CITY OF ALBUQUERQUE

February 20, 2025

**RE: Eagle Ranch Retail
9641 Eagle Ranch Rd NW
Grading and Grading Plan
Engineer's Stamp Date: 1-21-2025
Hydrology File: B13D002C**

Based upon the information provided in your submittal received 02/06/2025, the Grading and Drainage Plan **is not** approved for Grading Permit and Paving Permit. The following comments need to be addressed for approval of the above referenced project:

C-1.0

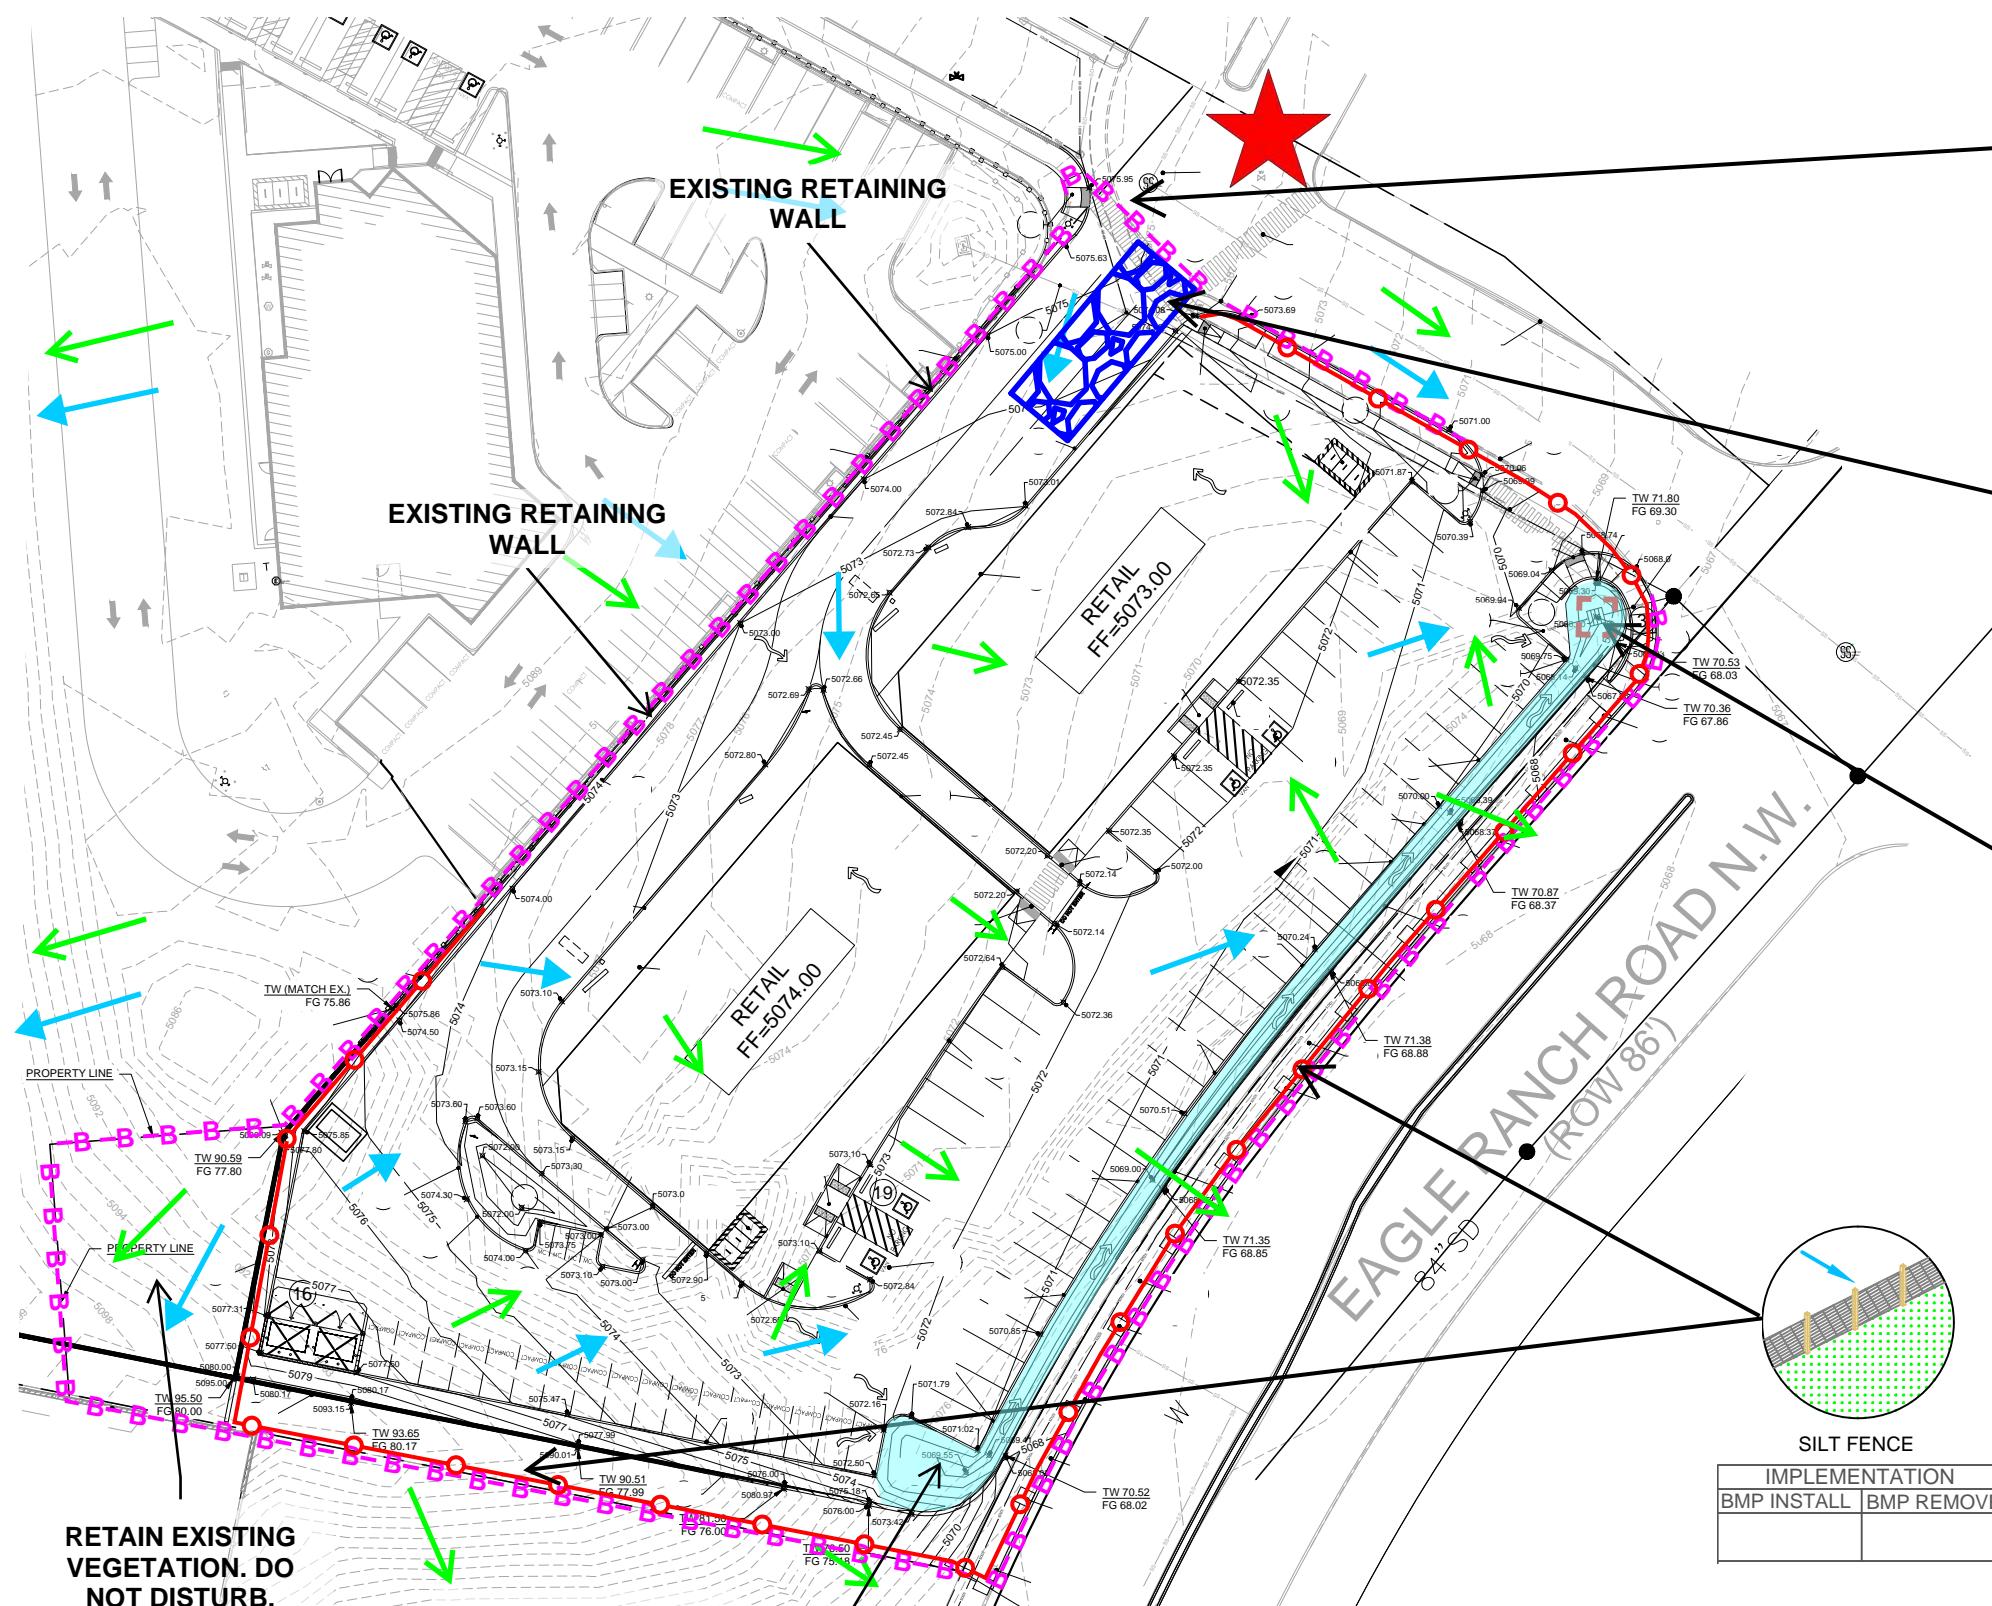
1. Please provide the FIRM Map and floodplain note with effective date.

2. Please provide the Benchmark information (location, description and elevation) for the survey contour information provided.

3. Show the calculation for the Storm Water Quality Volume required. Please follow the DPM Article 6-12 Stormwater Quality and Low-Impact Development for the sizing calculations. To calculate the required SWQV, multiply the impervious area draining to the BMP by 0.42 inches for new development sites. The calculations of both the required and the provided volume of each BMP must be shown on the Grading and Drainage Plan. Each BMP should be labeled on the Grading and Drainage Plan with the required SWQV and associated water surface elevation and the 100-year water surface elevation.
